**Oakdale South Industrial Estate – Stage 4 – Costco Wholesale (SSD 8209)
Submission on behalf of Jacfin Pty Ltd**

**Re: Costco Development at Oakdale South Estate
Assessment of Noise Impact upon Jacfin Residential Land**

Drawing Title  
SITEWORKS SECTIONS  
SHEET 1 OF 2

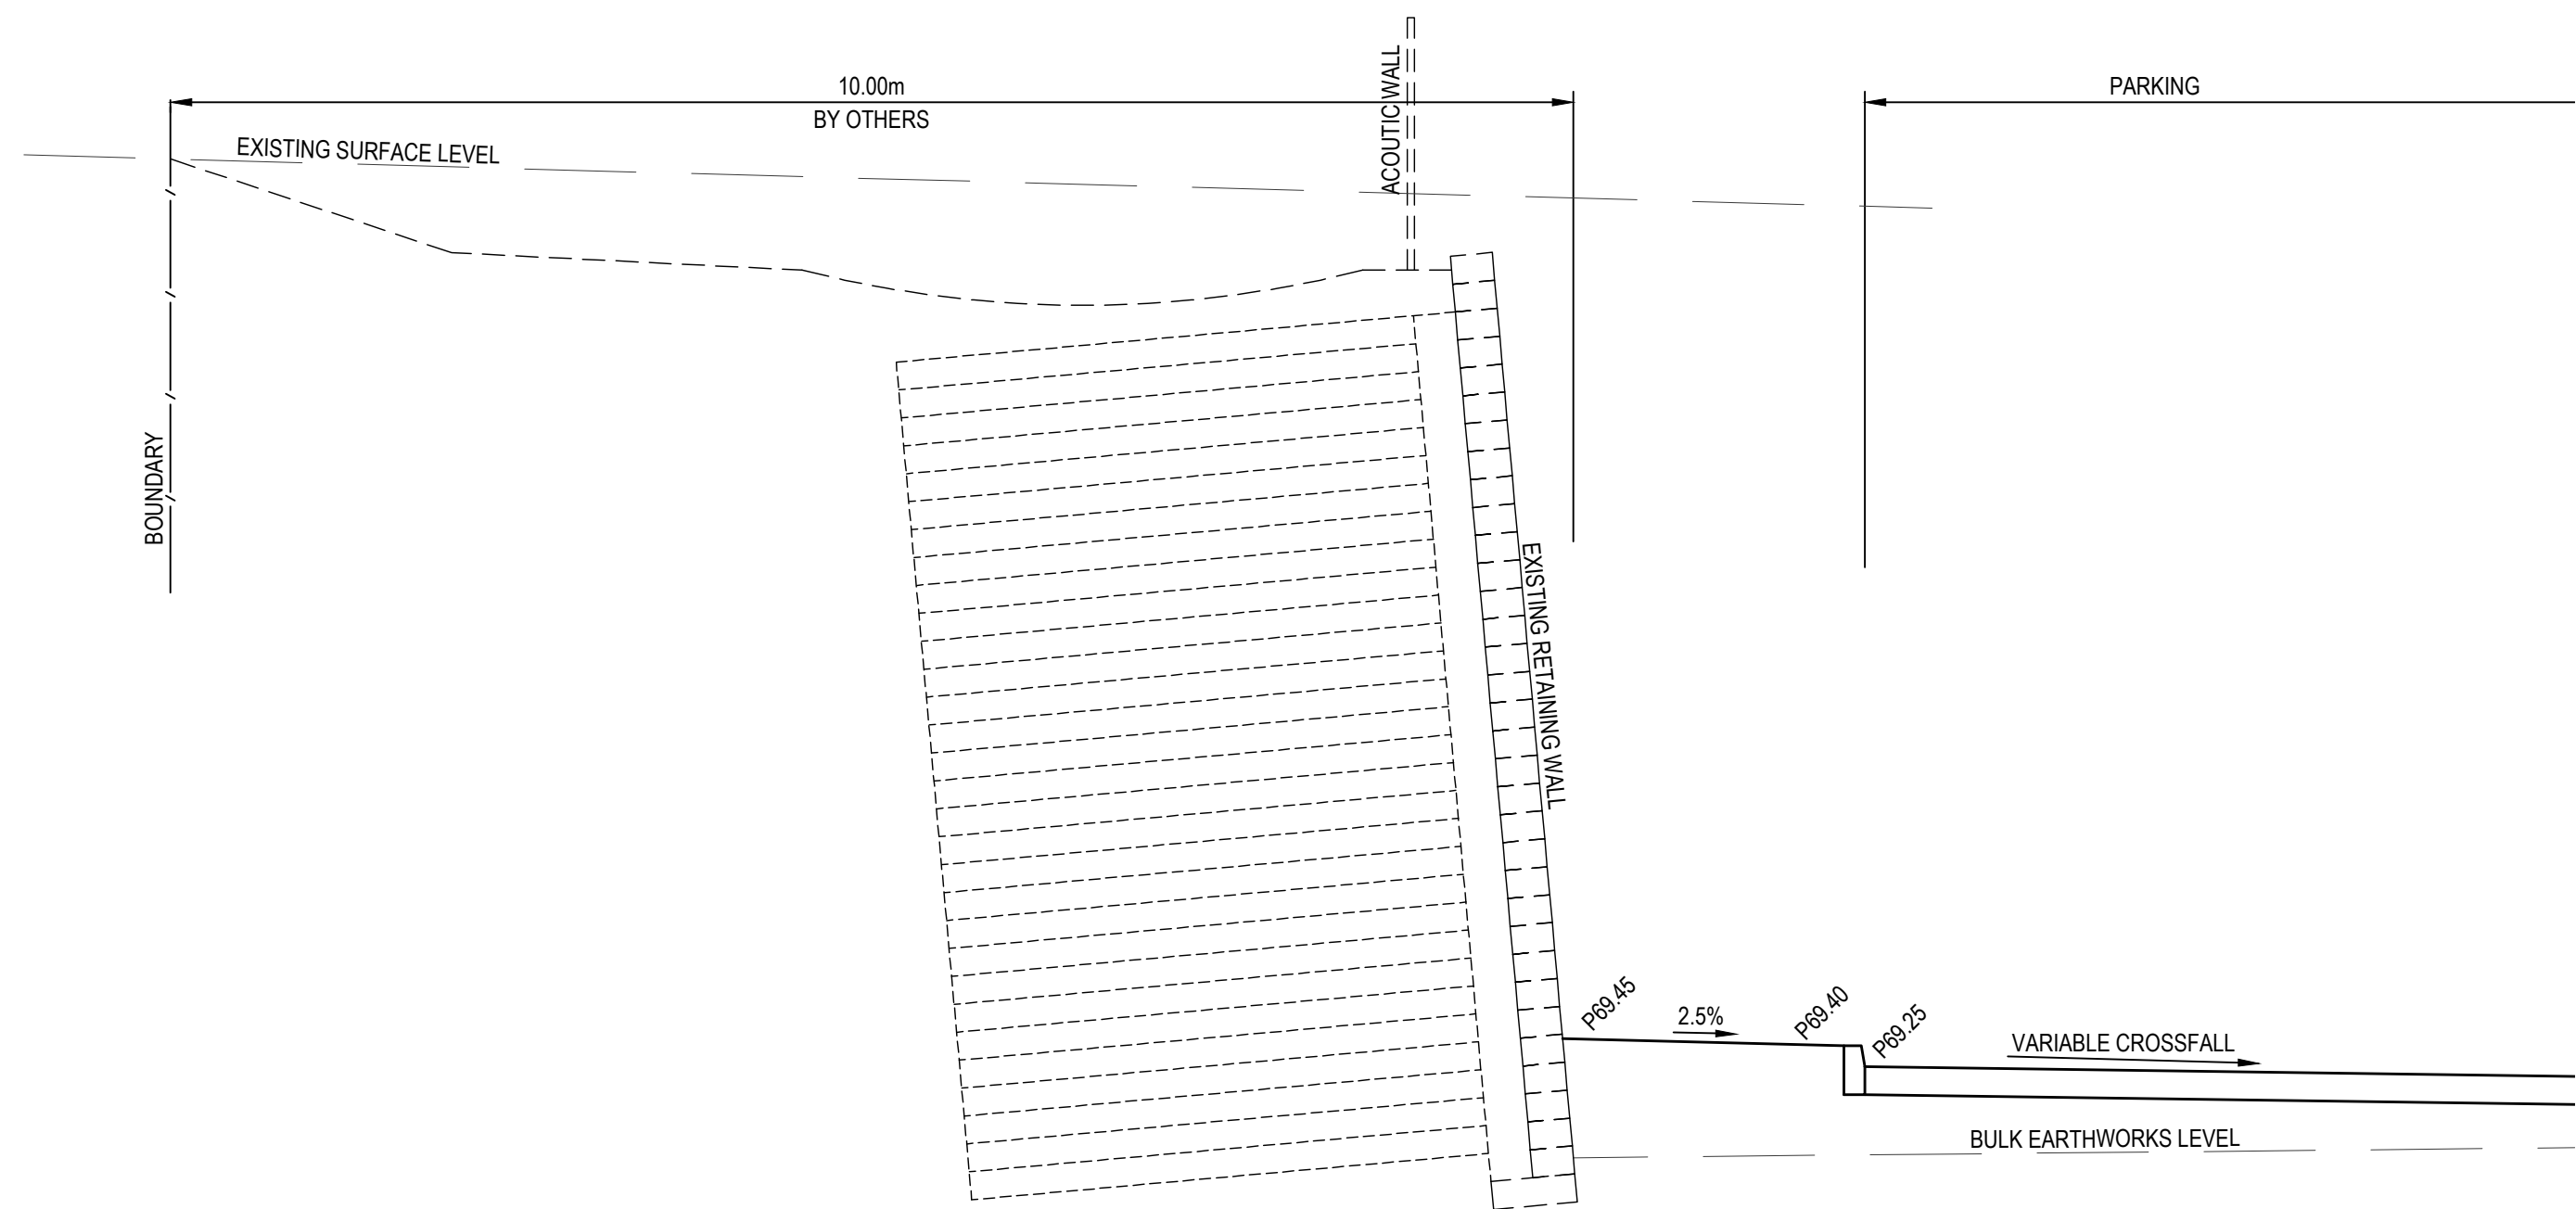
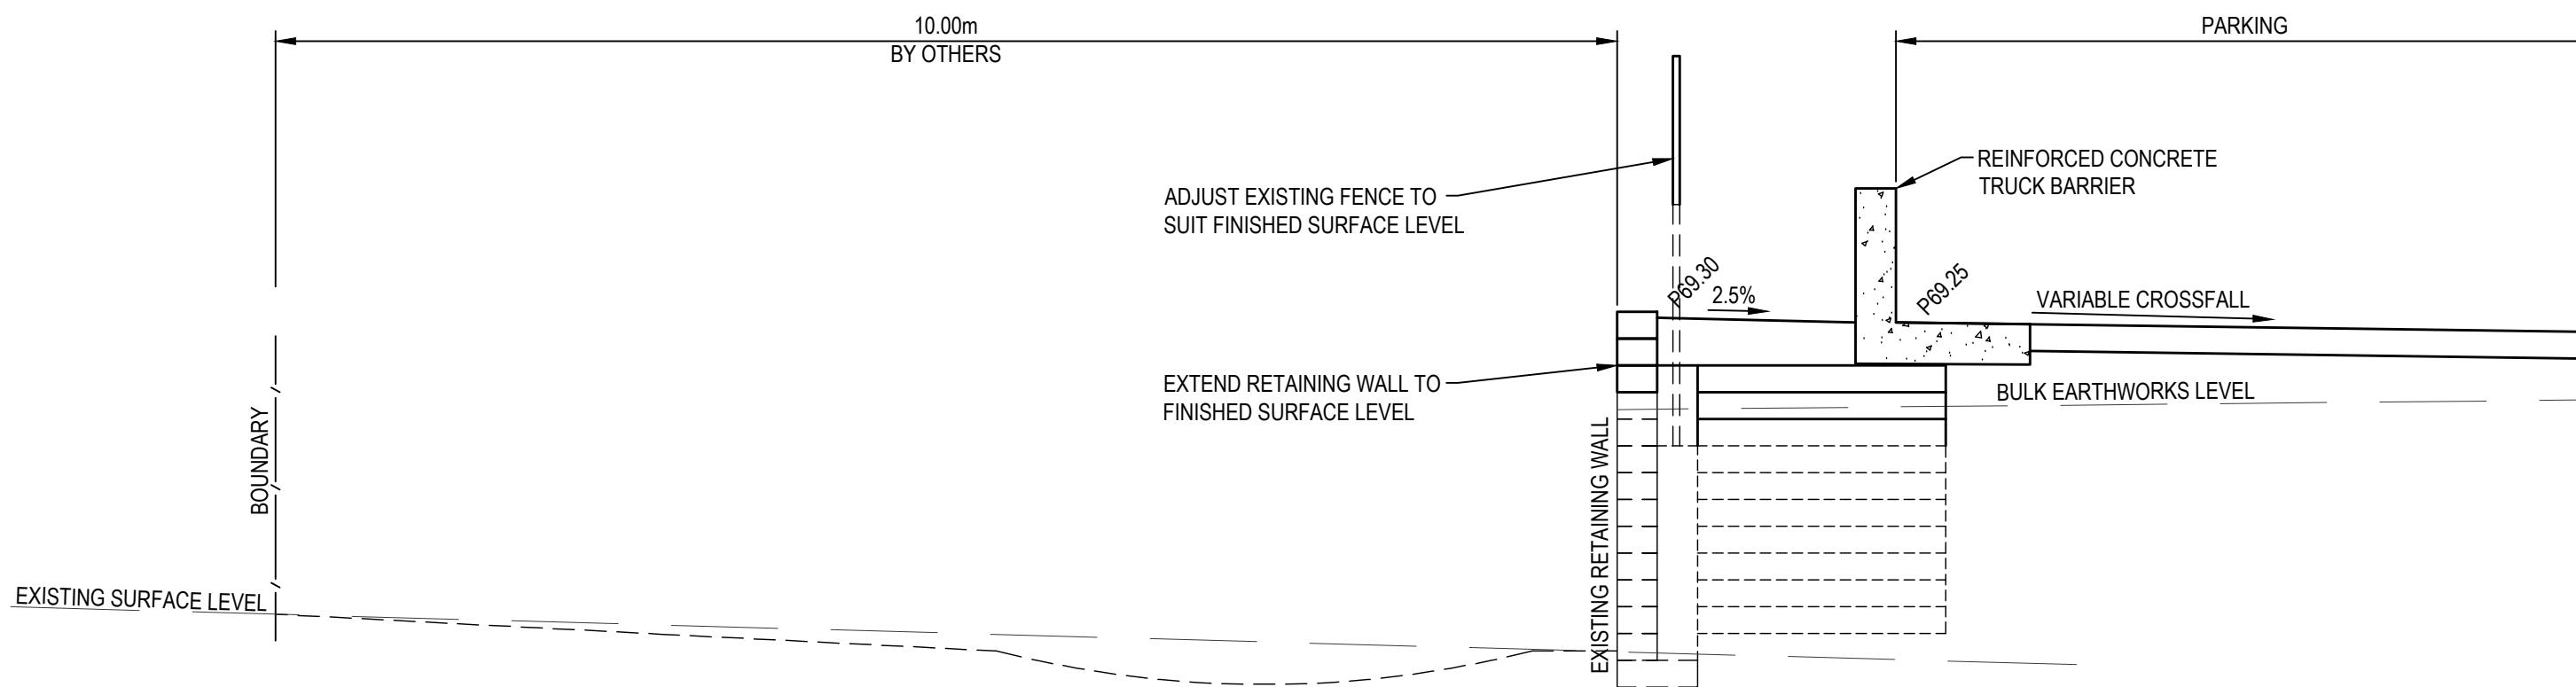
The Stage 1 Consent, as modified, requires the construction of a 5 metre high noise wall along a portion of the eastern boundary of the OSE. Based on the errors identified by Wilkinson Murray in the Noise Report, Wilkinson Murray has concluded that the approved noise wall will be insufficient to prevent unacceptable noise impacts on the Jacfin Land.

Wilkinson Murray has indicated that the noise wall will need to be increased in height to 7 metres in order for the applicable night time noise criteria for the development to be achieved at the Jacfin Land, upon correcting the assumptions adopted in the modelling undertaken by SLR. Calculations undertaken by Wilkinson Murray show that the higher wall would reduce noise from the proposed development by approximately 2dBA, thereby rendering the proposed development compliant.

Given this, there is a risk that the proposed development will result in unacceptable noise impacts on the Jacfin Land. To mitigate this, the proposed 5 metre noise wall should be extended in height to a total height of 7 metres. Such an increase in height is expected to reduce $L_{A1,1min}$ noise levels at the Jacfin Land by approximately 2dB.

Jacfin submits that any consent granted in relation to the Costco DA should include a condition requiring the construction of a 7 metre noise wall to mitigate the noise impacts of the proposed development.

- The wall proposed on the eastern site boundary of the Costco development should be of height 7 metres above the retaining wall;
- No forklift should operate on the premises outside of the warehouse building;
